# The Planning Inspectorate

Our Ref: TR010039

### **Application by Highways England for an Order Granting Development Consent for the A47 Wansford to Sutton scheme**

#### **Advice following issue of decision to accept the application for examination**

DRAWING NUMBER
HE551494-GTY-HGN-000-DR-CH-35001

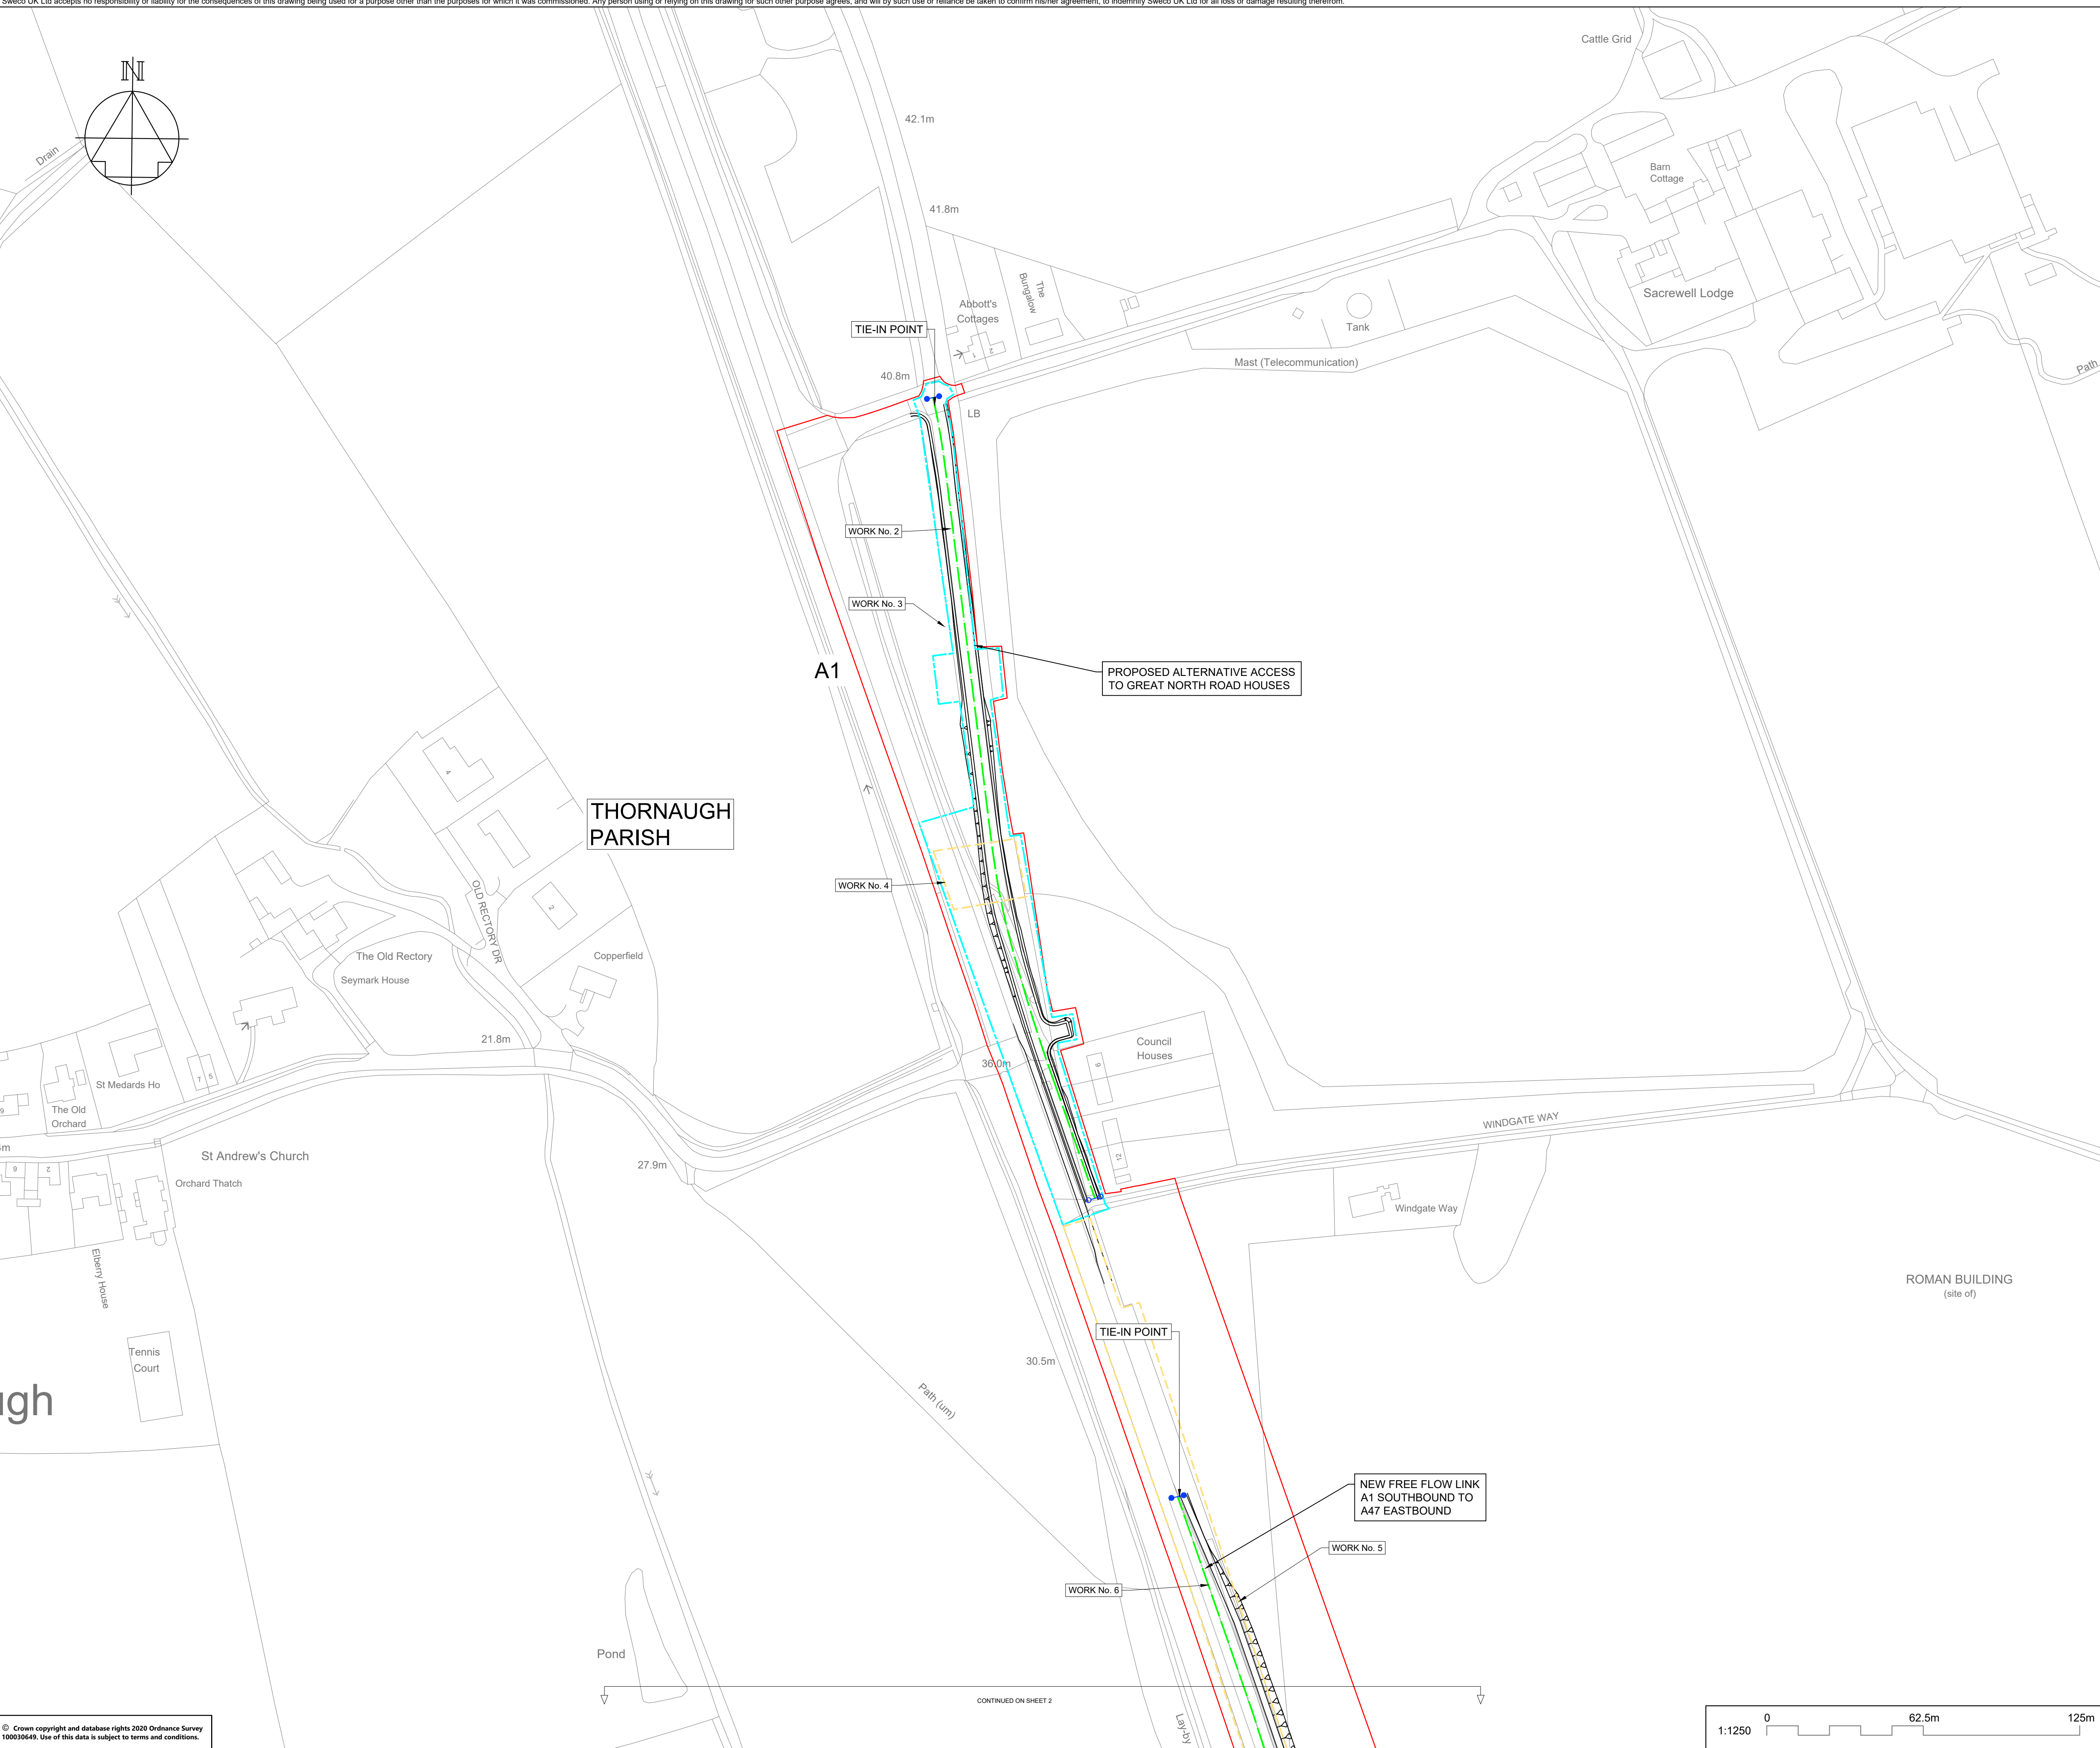
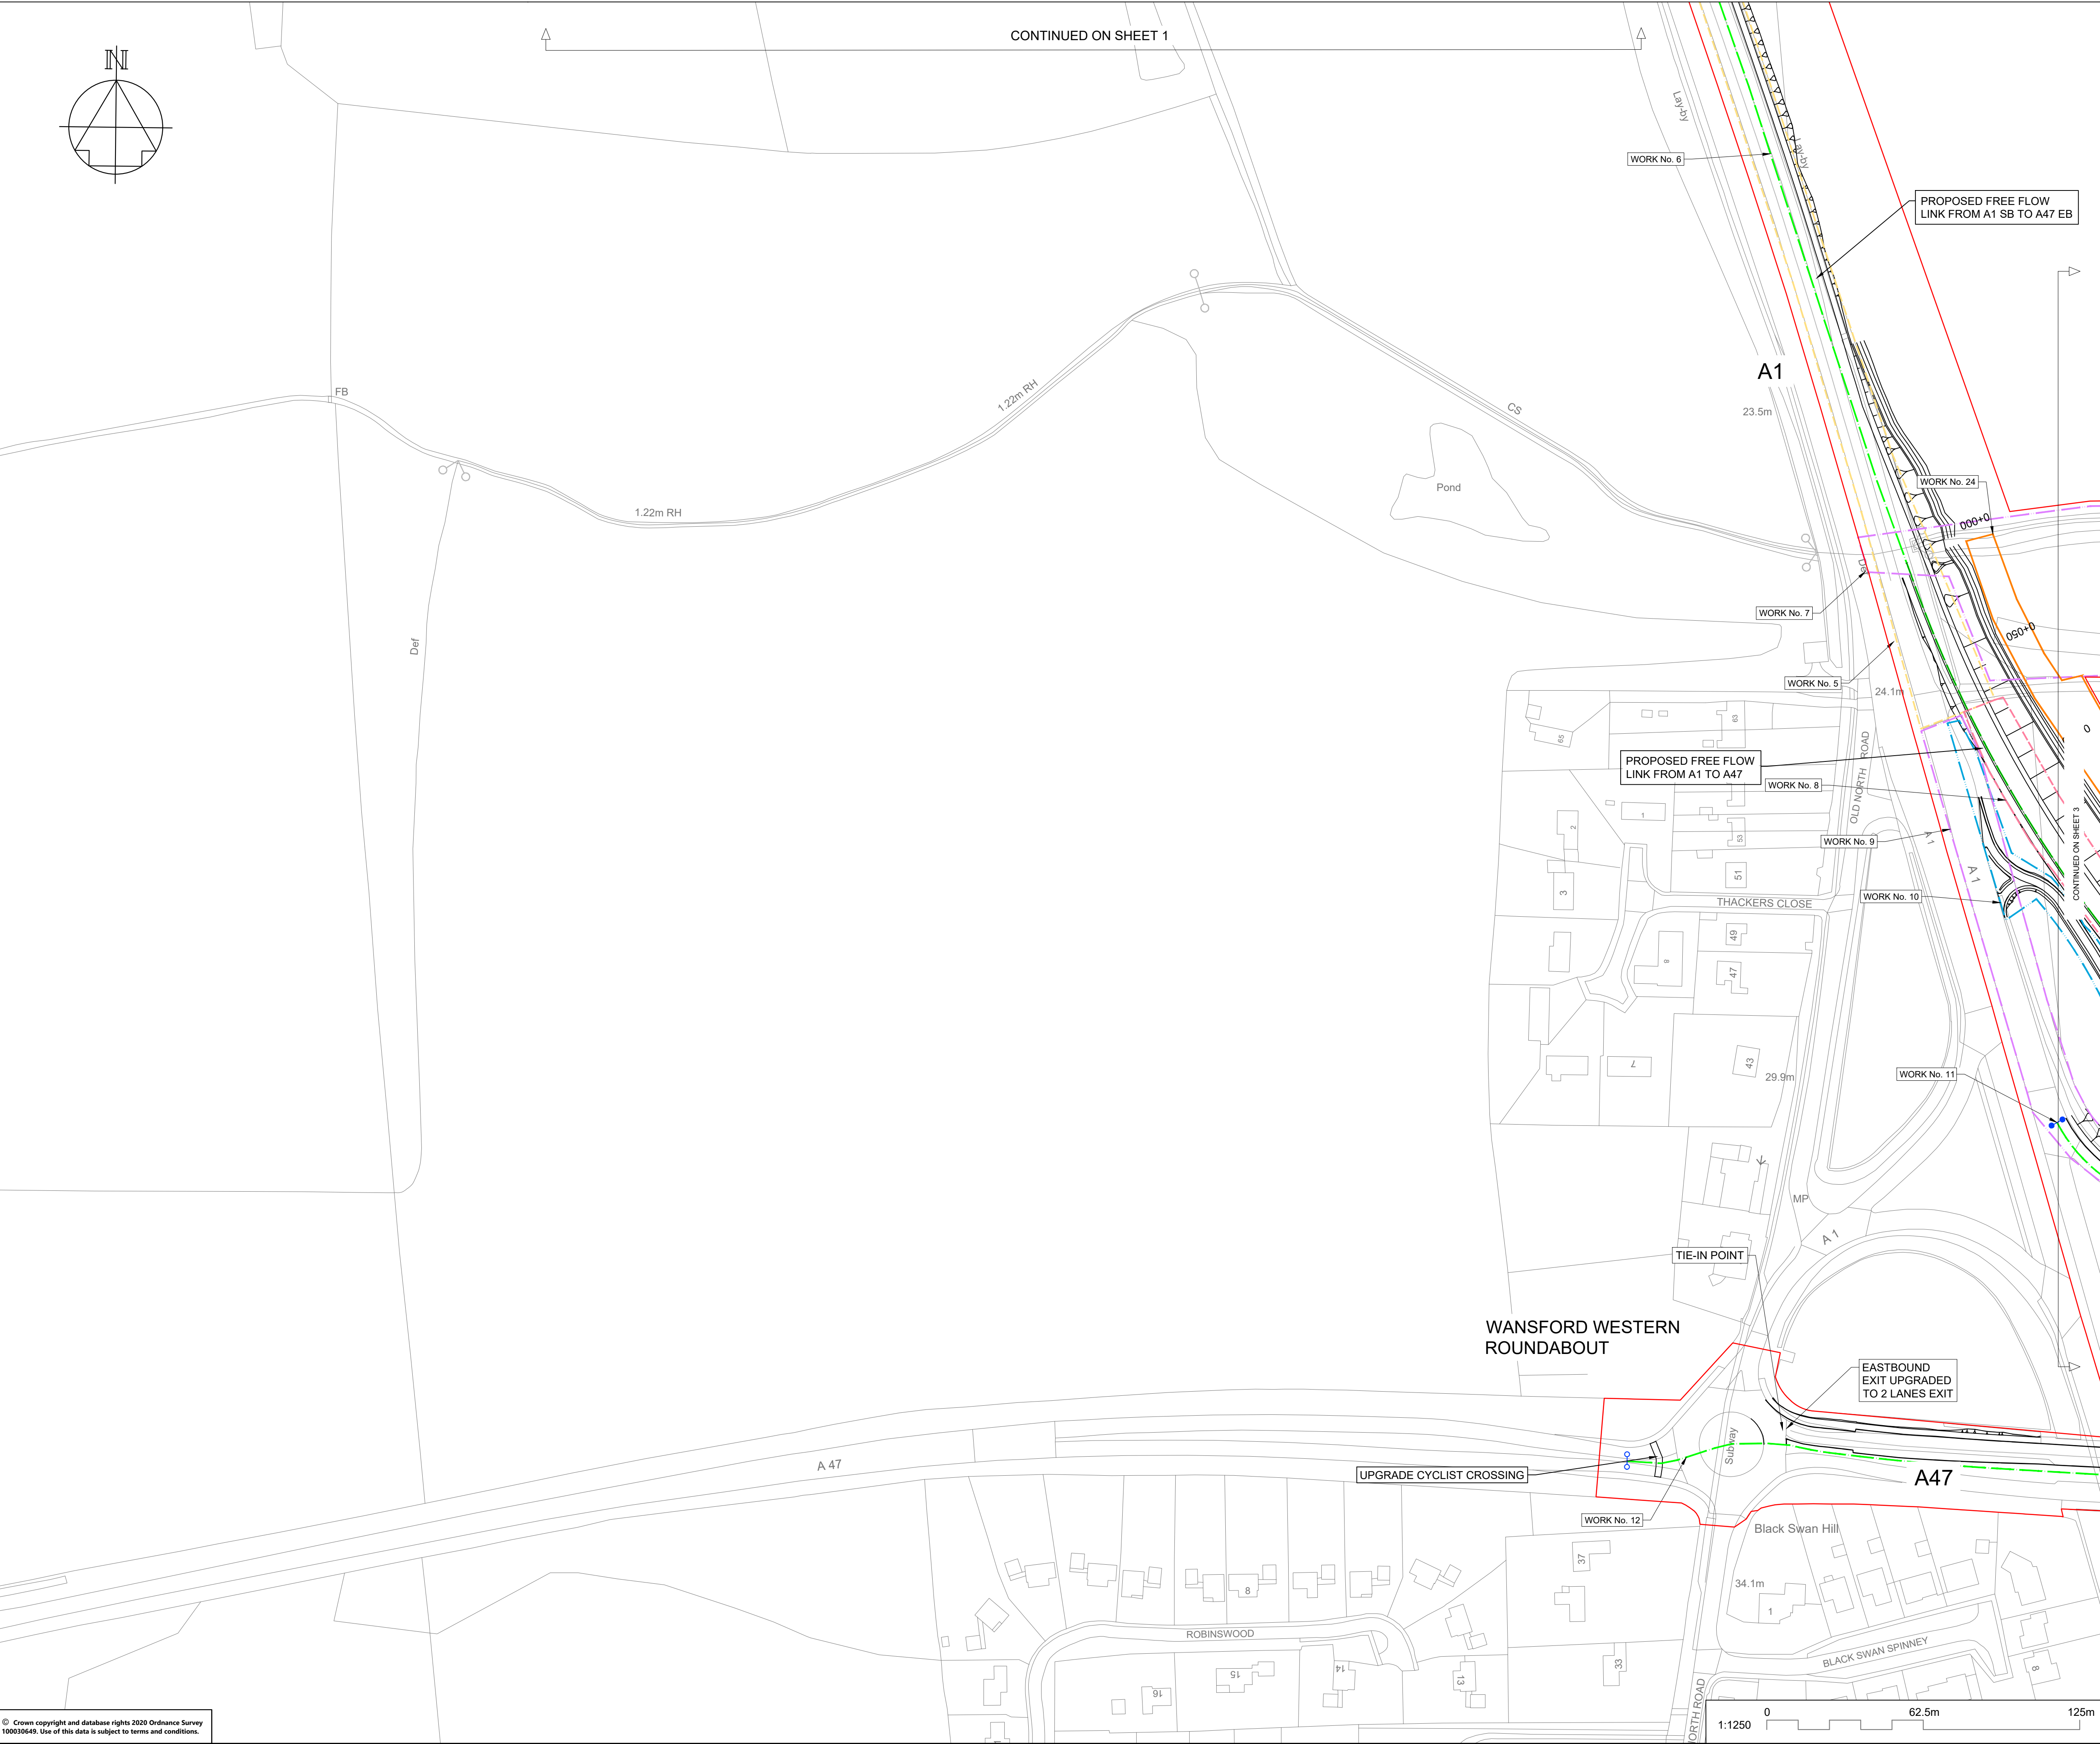
The Works Plans (Doc 2.3) do not clearly show the location and extent of the proposed compounds. The Inspectorate identified other minor discrepancies while checking the plans submitted as part of the application documents. Examples of errors are provided in Box 30, and the Applicant is advised to thoroughly check the plans for any corrections necessary. With this in mind the Applicant may want to consider submitting a revised set of Works Plans that:

- show the extent and location of the construction compounds; and

- represent the extent of the proposed works with annotations that are much easier to follow.
